Date: 18 May 2022

Application by Awel y Môr Offshore Wind Farm Limited for an Order Granting Development Consent for the Awel y Môr Offshore Wind Farm

Advice following issue of decision to accept the application for examination

[Continues on Sheet No. 1]

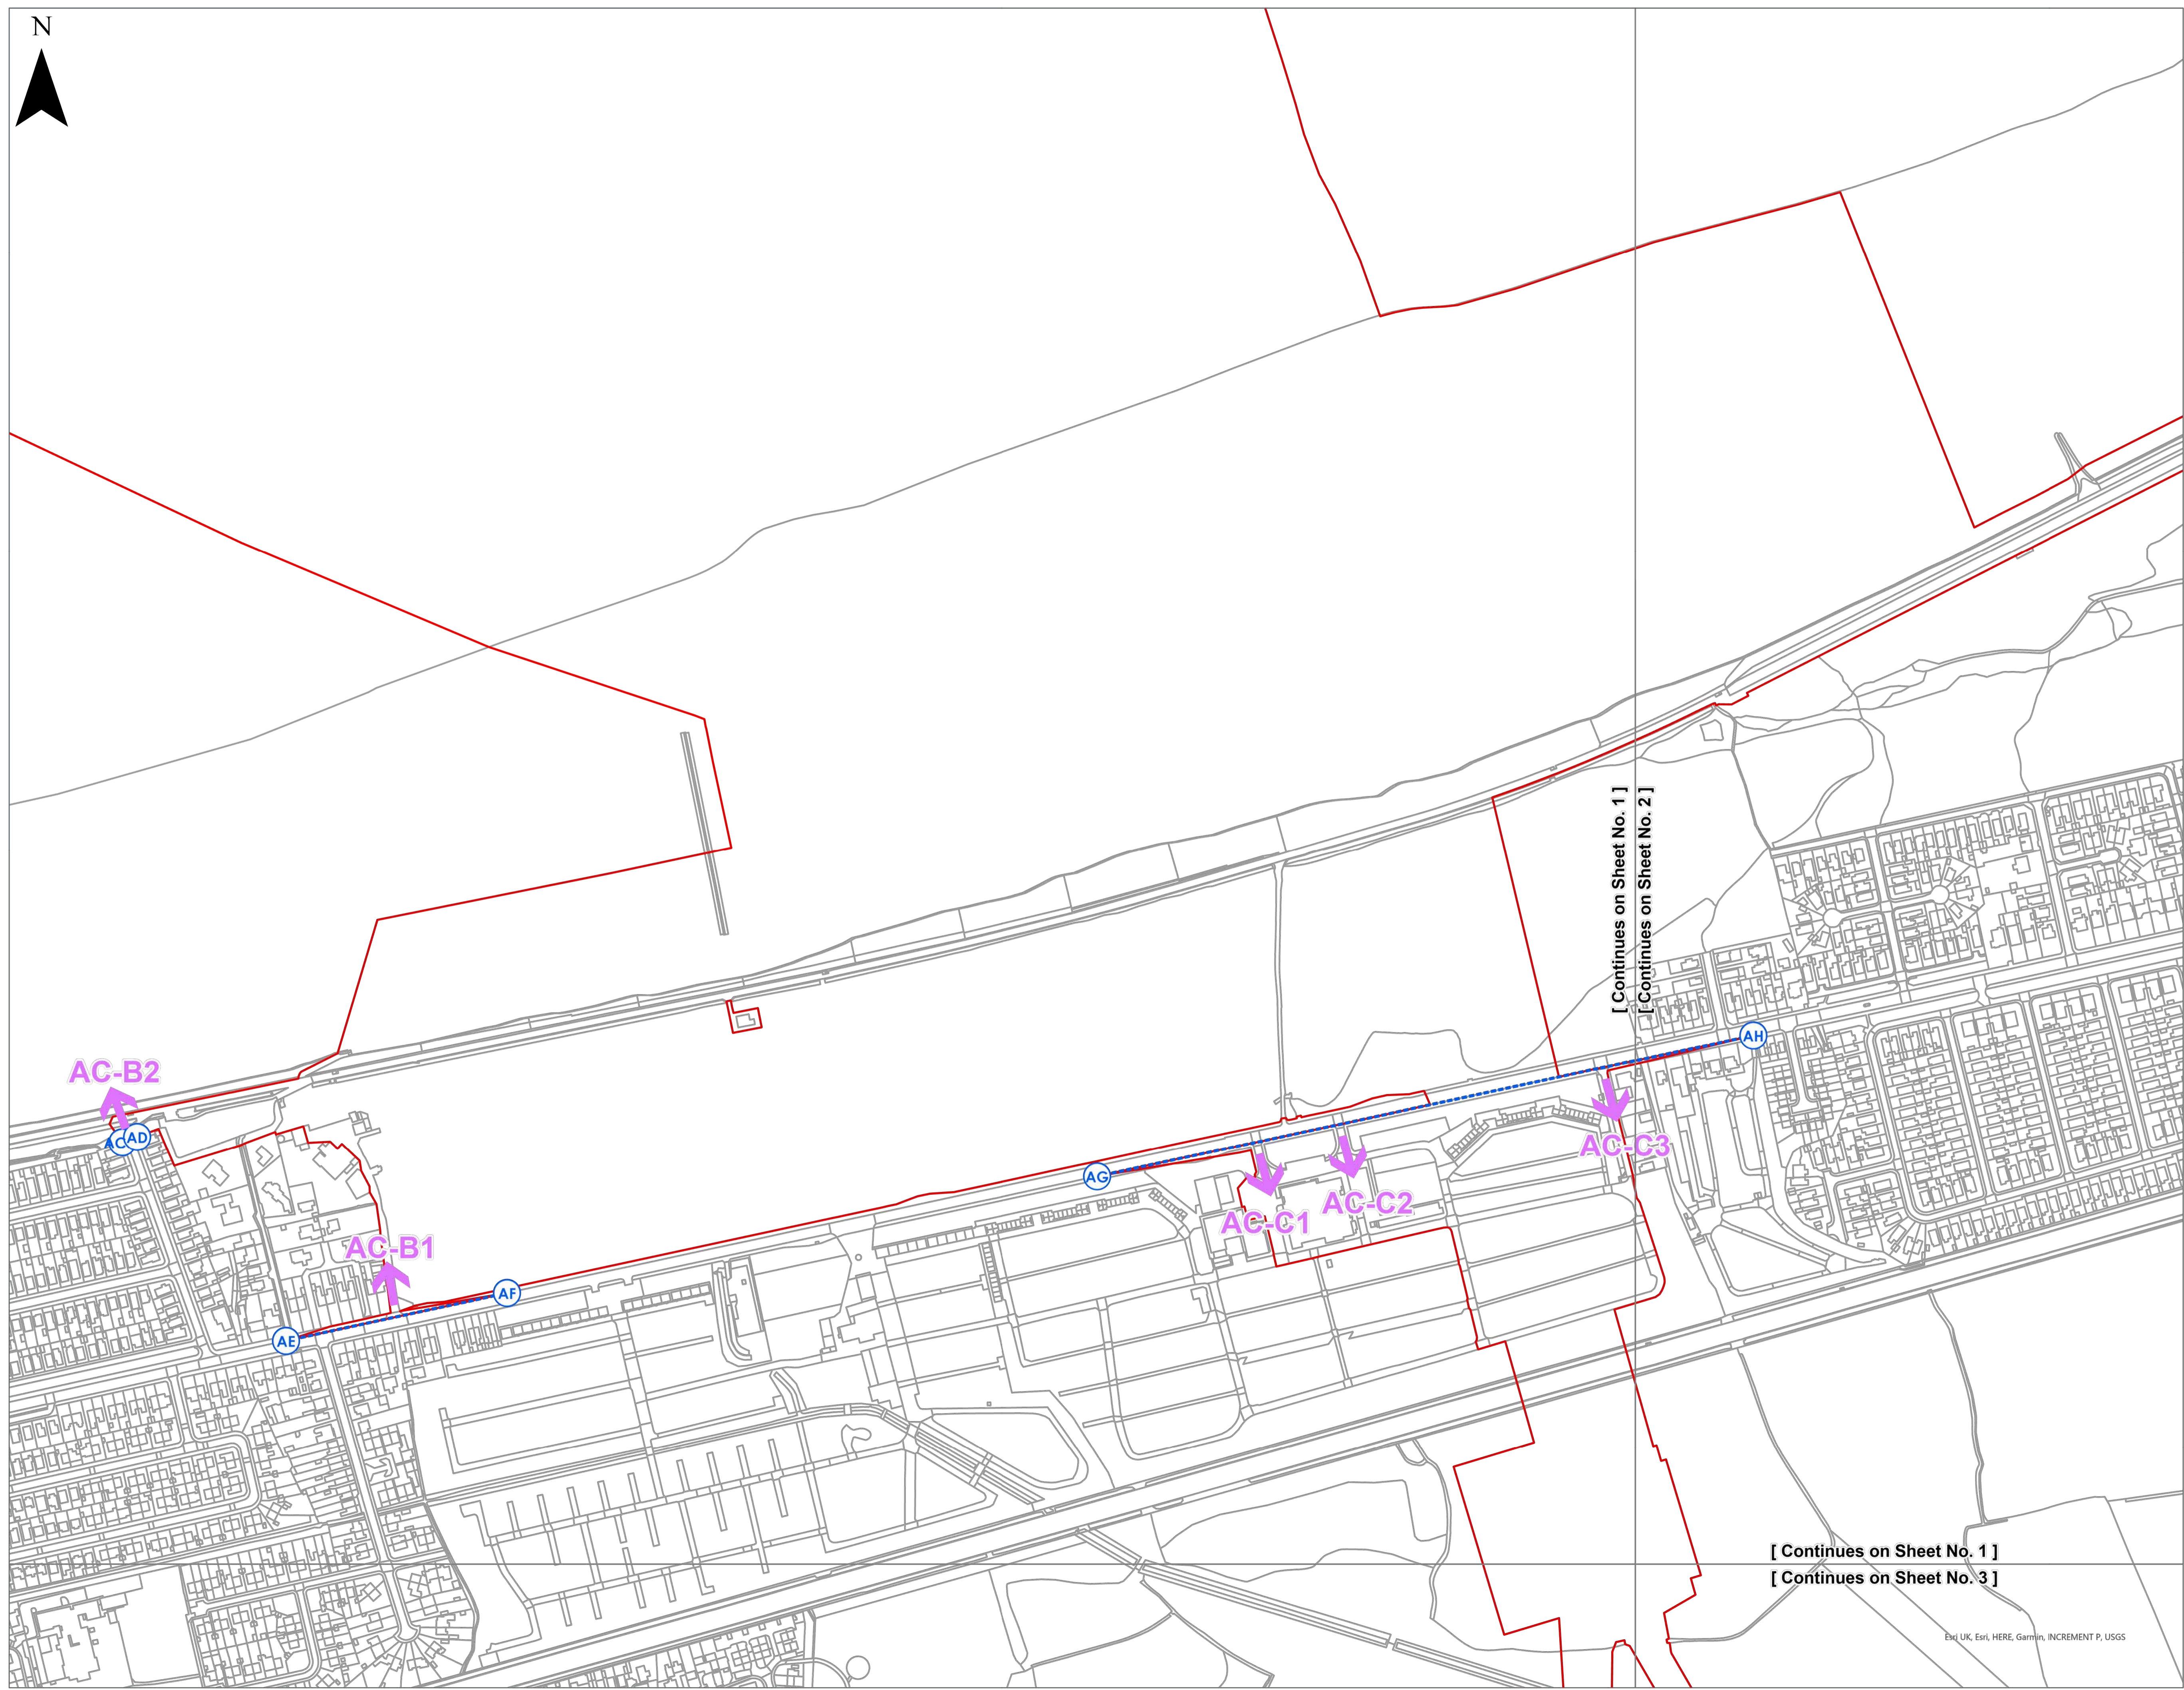
- The legend in the Street Works and Access Plan refers to Schedule 4 instead of Schedule 3 of the dDCO.
- Footpath names on the Temporary Stopping Up of Public Rights of Way Plans could be enlarged.

- Schedule 3 – points BI and BJ shown on the last page of the street works and access plan have been omitted.
- Schedule 4, columns 1 and 2 – inconsistencies between the information in these columns and the information shown on the temporary stopping up of public rights of way plan, and the naming of the plan is the 'temporary stopping up of public rights of way plan'.

- Schedule 5, column 1 – References to AC-Q do not appear on the street works and access plans. 'AC-Q1' and 'AC-Q2' appear on the plans but are omitted from Schedule 5. It would also be helpful to identify the relevant sheet numbers.
